DEVELOPMENT REVIEW BOARD
Action Sheet

1. **Project# 1004540**
11DRB-70366 MAJOR - AMENDMENT
TO PRELIMINARY PLAT

WILSON AND COMPANY INC agent(s) for AMAFCA request(s) the referenced/ above action(s) for all or a portion of Block(s) 2 & 5, Unit 25 and Block 2, Unit 14 **VOLCANO CLIFFS SUBDIVISION & Tract D, VISTA VIEJA SUBDIVISION UNIT 2** [approved and TBKA **BOCA NEGRA DETENTION DAM**], zoned R-1 & R-D, located at the 81ST ST NW BETWEEN UNSER BLVD NW AND COMPASS DR NW containing approximately 26.9937 acre(s). (D-9&-10) **THE AMENDED PRELIMINARY PLAT APPROVED. THIS AMENDMENT DOES NOT EXTEND THE EXPIRATION DATE OF THE ALREADY APPROVED PRELIMINARY PLAT.**

**PLAT OF TRACT 1
BOCA NEGRA DETENTION DAM**

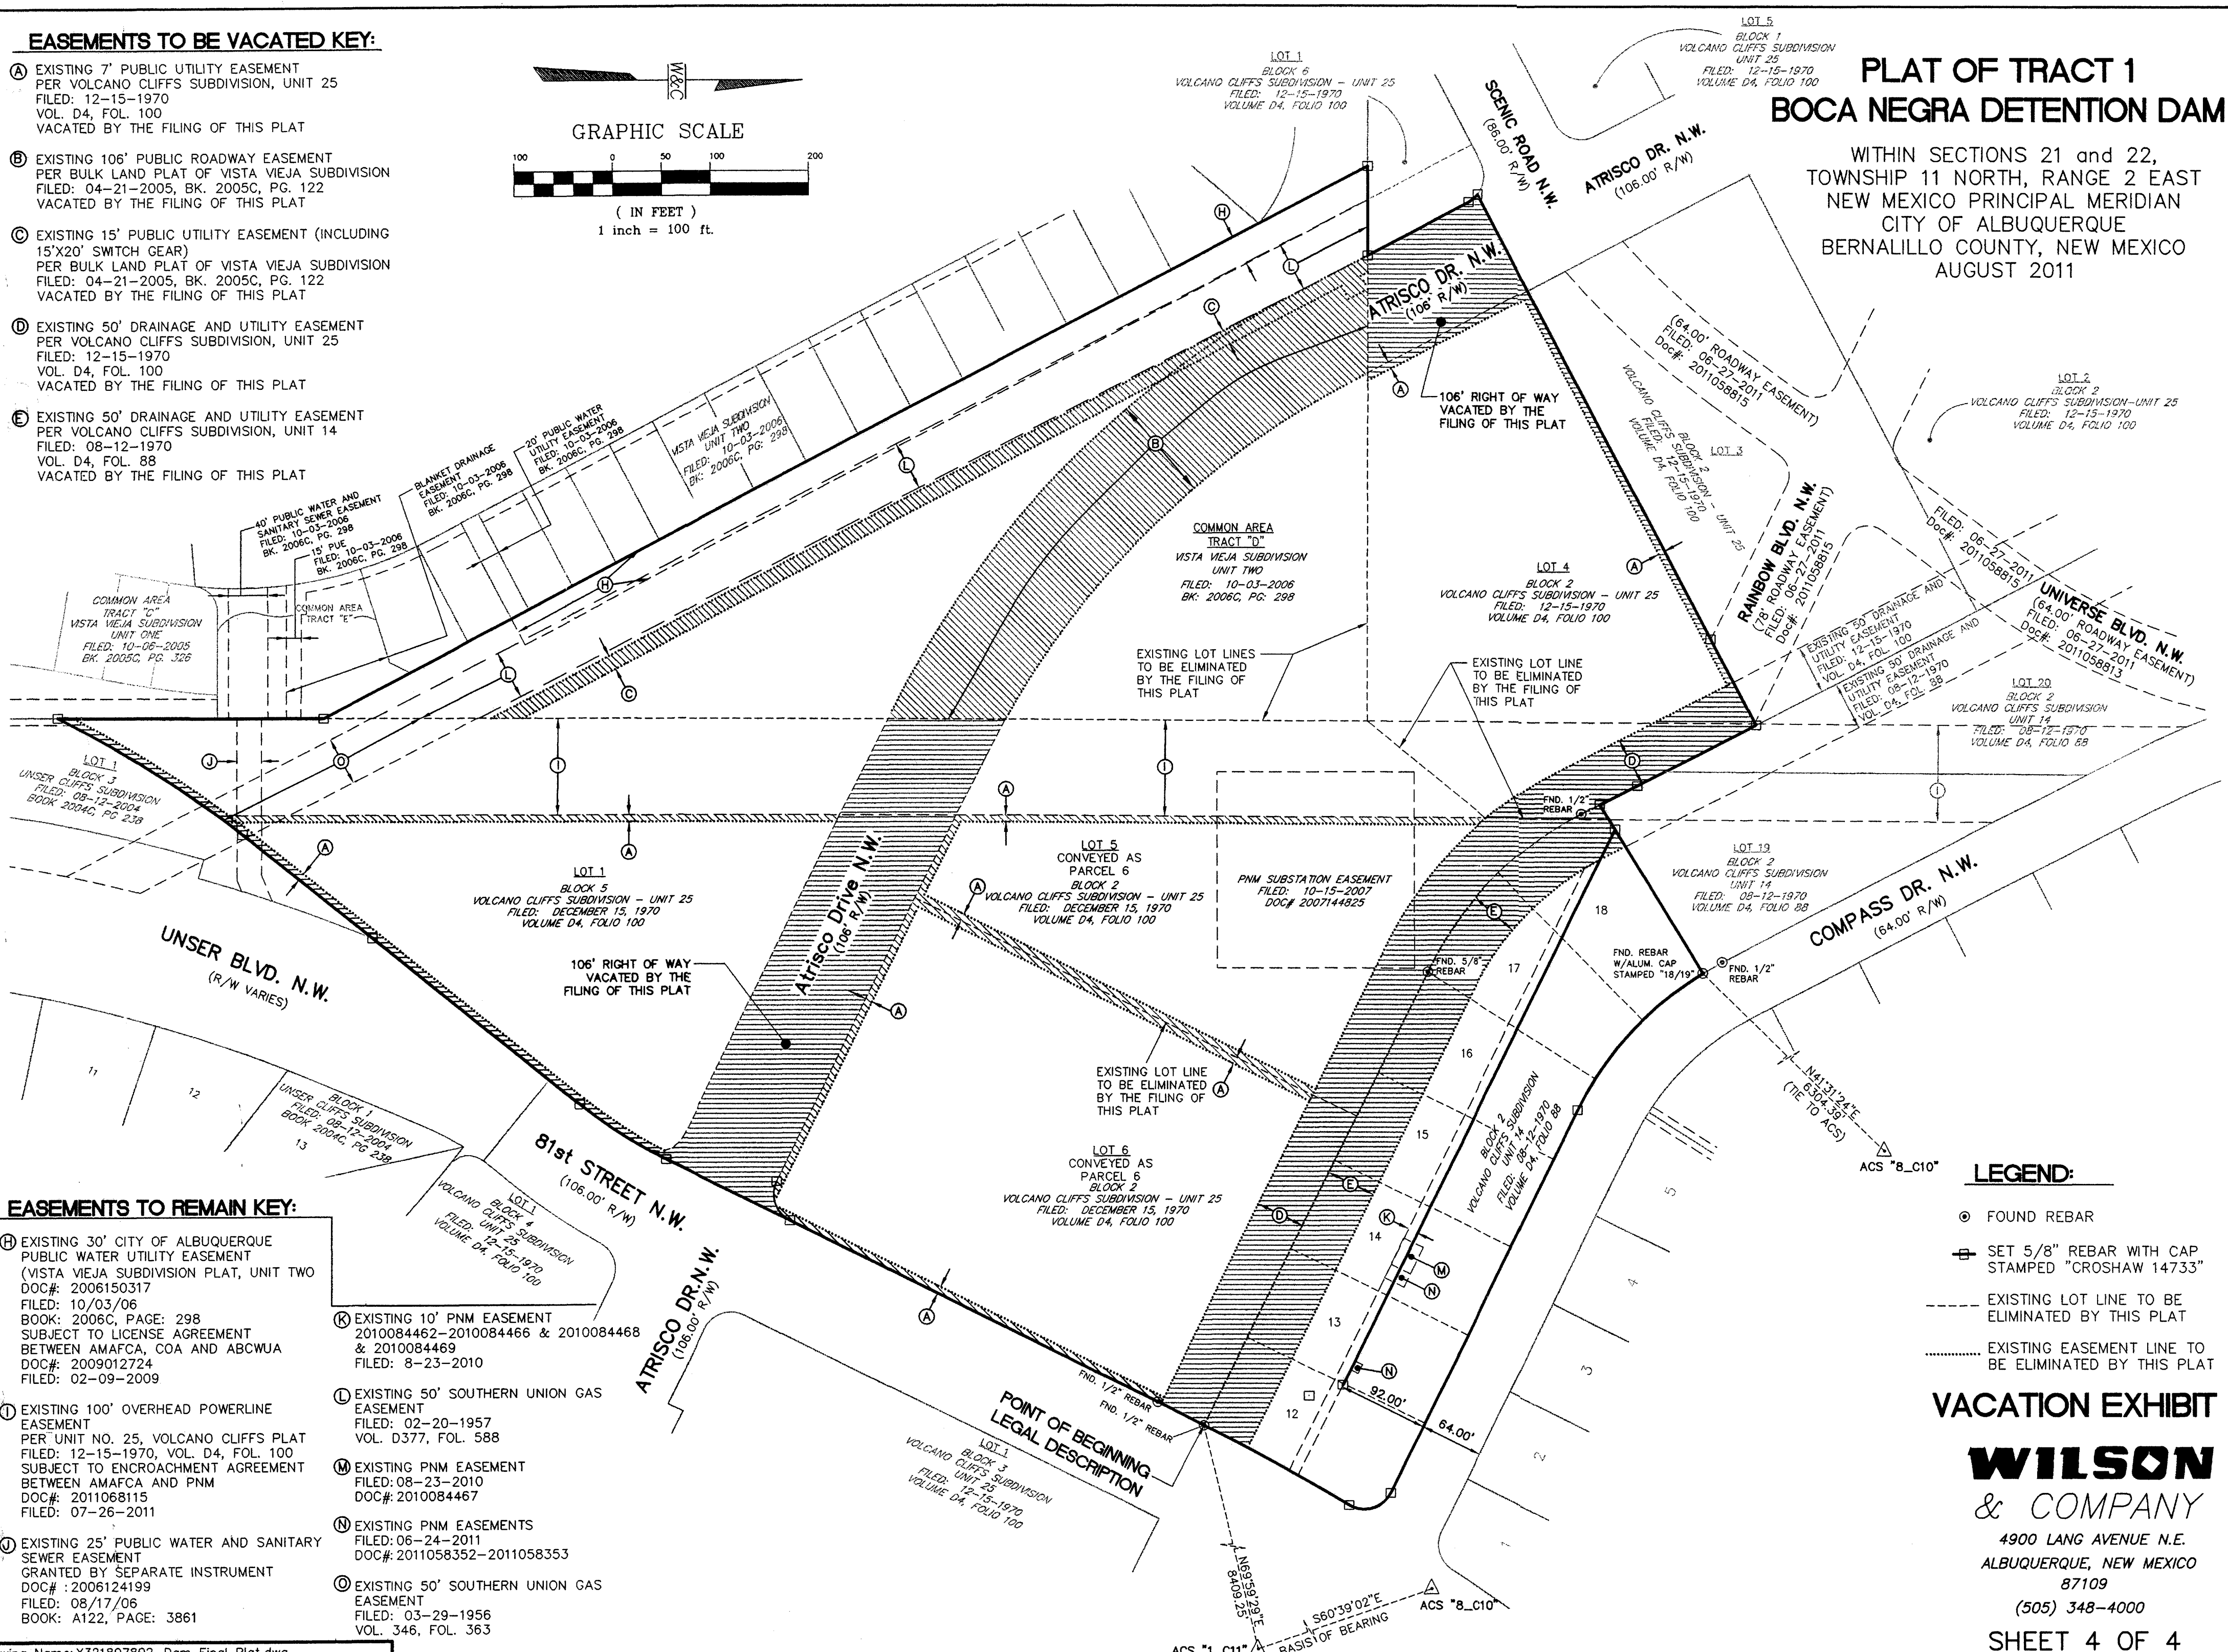
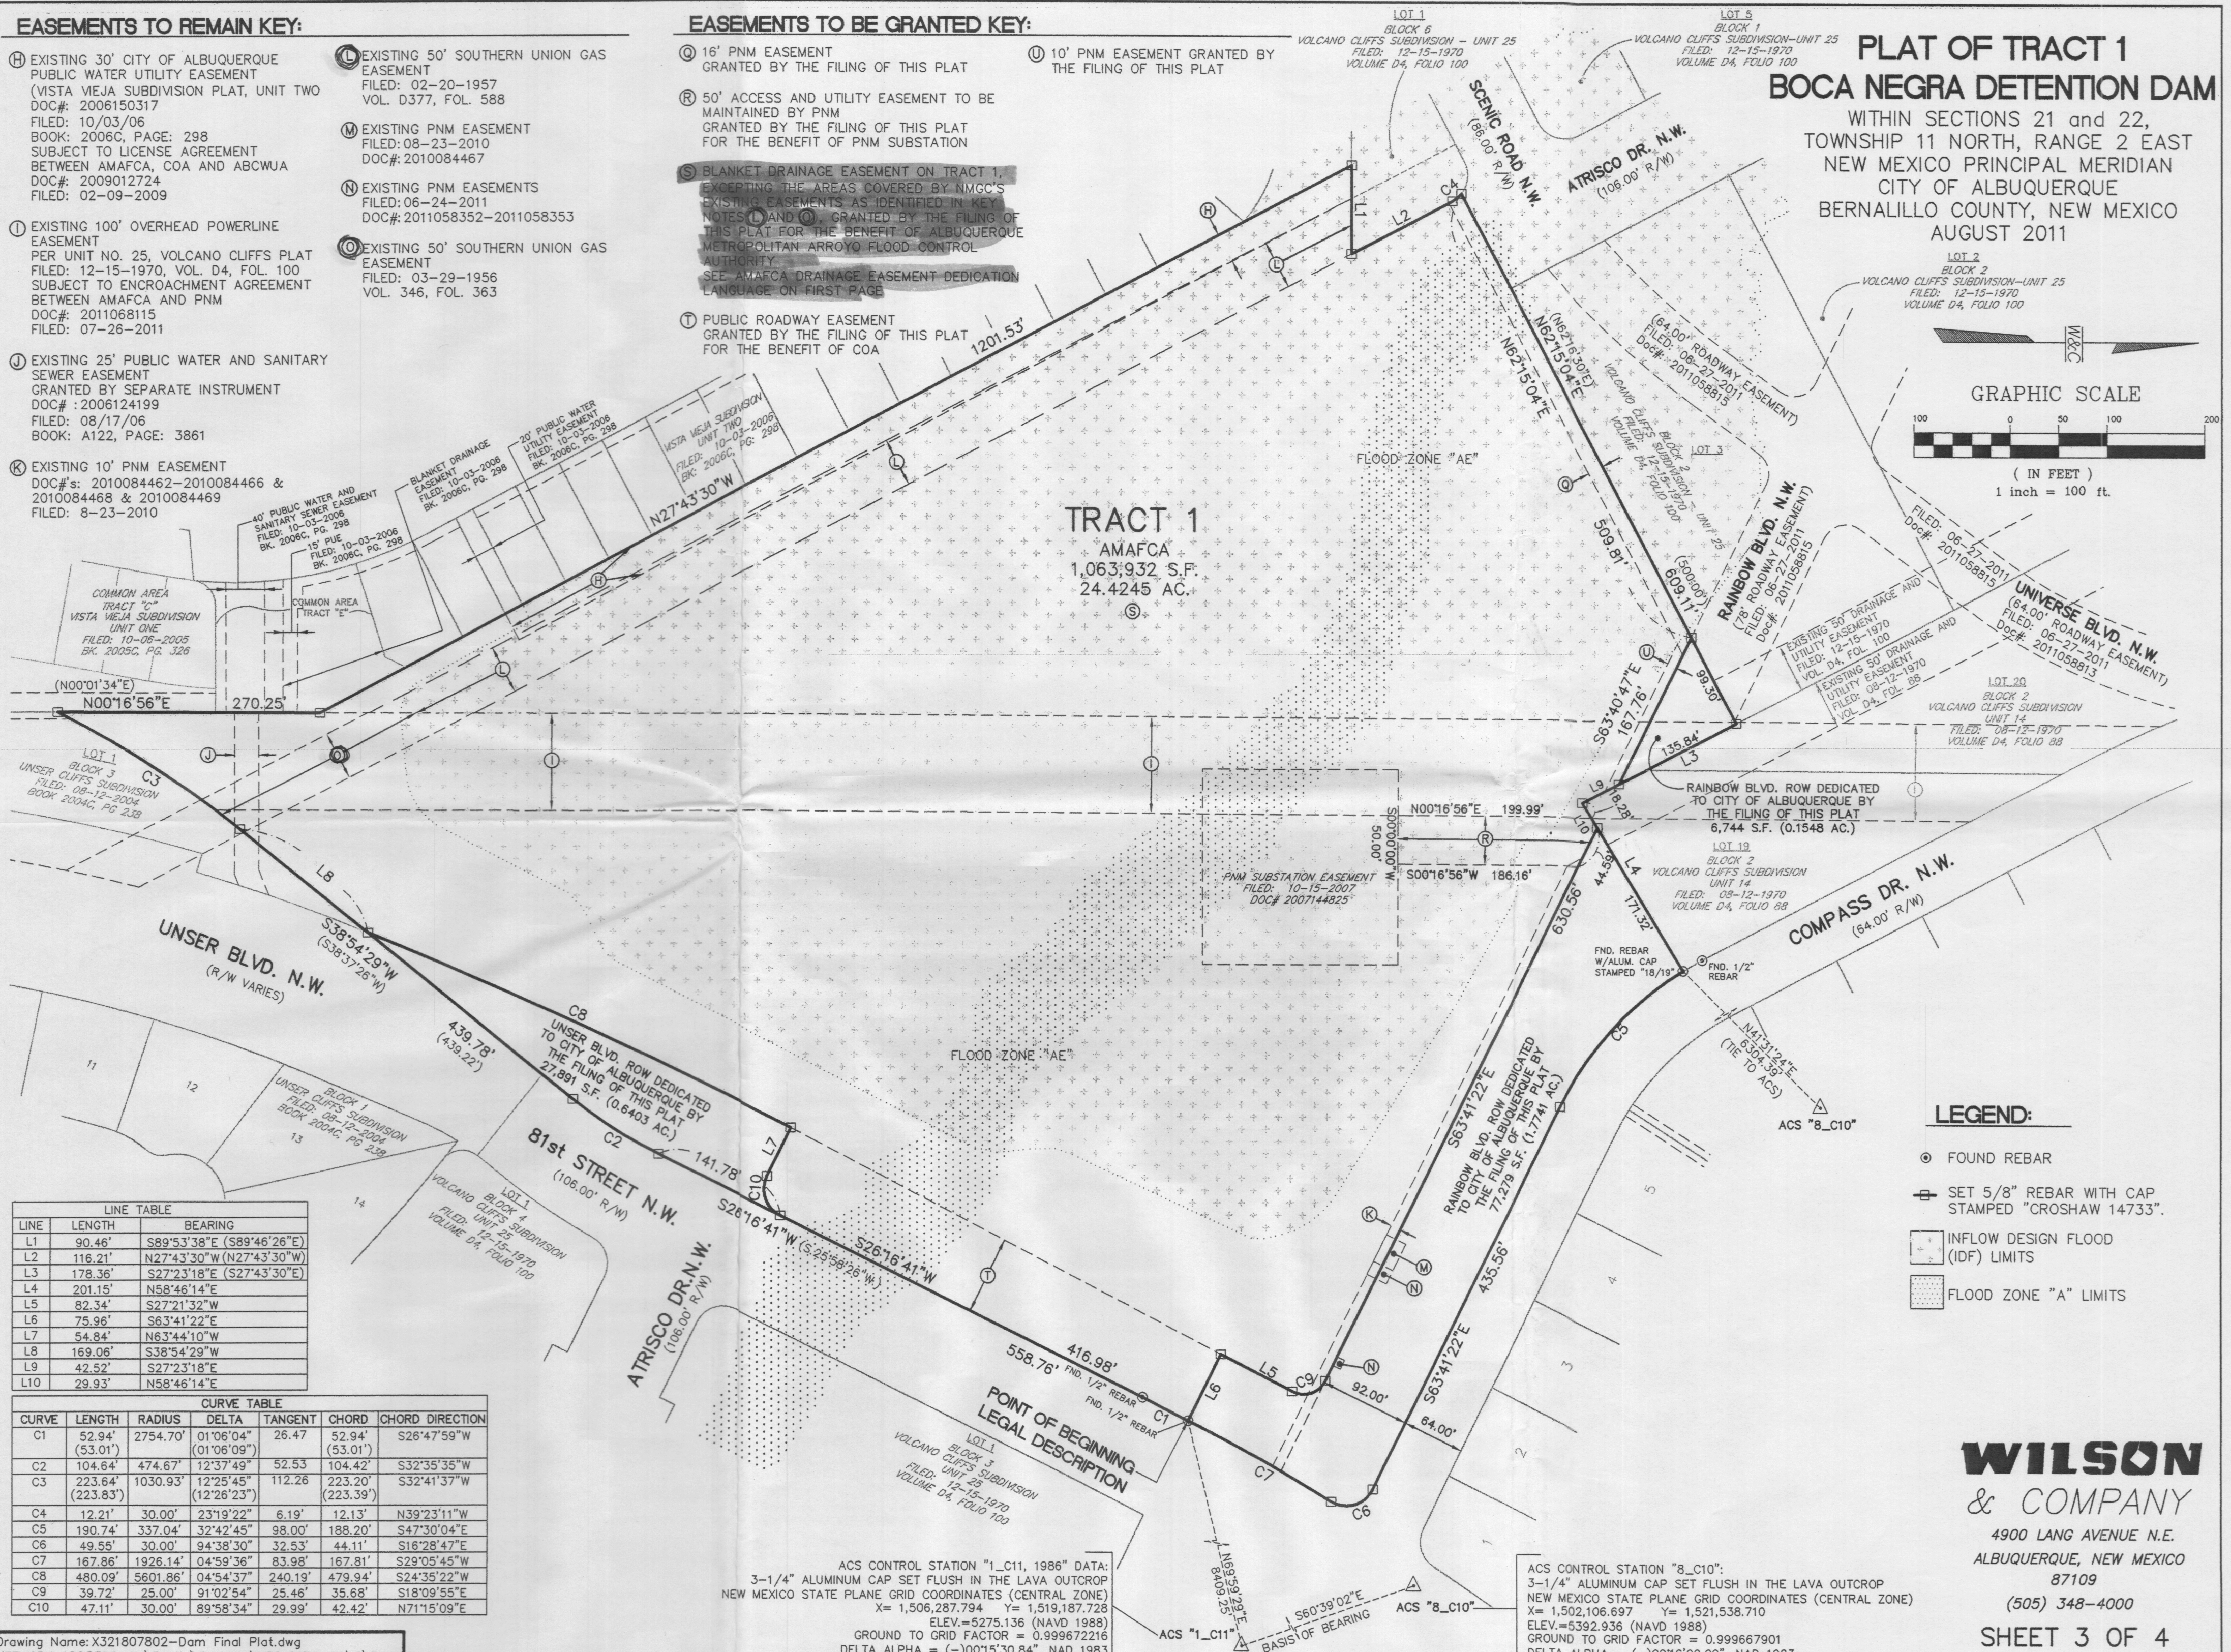
<p>ENVIRONMENTAL HEALTH No comments</p>
<p>M.R.G.C.D No comments</p>
<p>OPEN SPACE DIVISION No comments</p>
<p>CITY ENGINEER Hydrology has no objections to all of the requests.</p>
<p>TRANSPORTATION DEVELOPMENT It is unclear why a portion of the Unser frontage is being dedicated as public right of way, while another portion is being encumbered with a public roadway easement. Please clarify.</p> <p>Provide an exhibit showing the location of sidewalk and defining the distance from face of curb to the property line. Right of way dedication may be required.</p> <p>Define the width of all right of way.</p> <p>Clarify existing roadway conditions. Infrastructure improvements may be required</p>
<p>PARKS AND RECREATION Parks and Recreation is coordinating with AMAFCA for trail and other possible recreation uses. No objections to Vacation of Public Easement, Vacation of Public Right-of-Way, Bulk Land Variance or Minor-Preliminary/Final Plat Approval.</p>

<p>ABCWUA A license agreement will be required between AMAFCA and ABCWUA before the Atrisco roadway vacation action can be approved. No other objections to the other vacation actions, or the bulk land variance.</p>
<p>PLANNING DEPARTMENT Refer to comments from affected agencies plus any public hearing comments regarding proposed vacations. Regarding remaining easements, is there a physical difference between Keyed Easements L and O? For new easement T, please describe as a PUBLIC Roadway Easement. Proposed plat does not appear to qualify for a Bulk Land Variance, because the DRB does not expect further public agency review for this parcel. Please describe the status of adjacent infrastructure.</p>
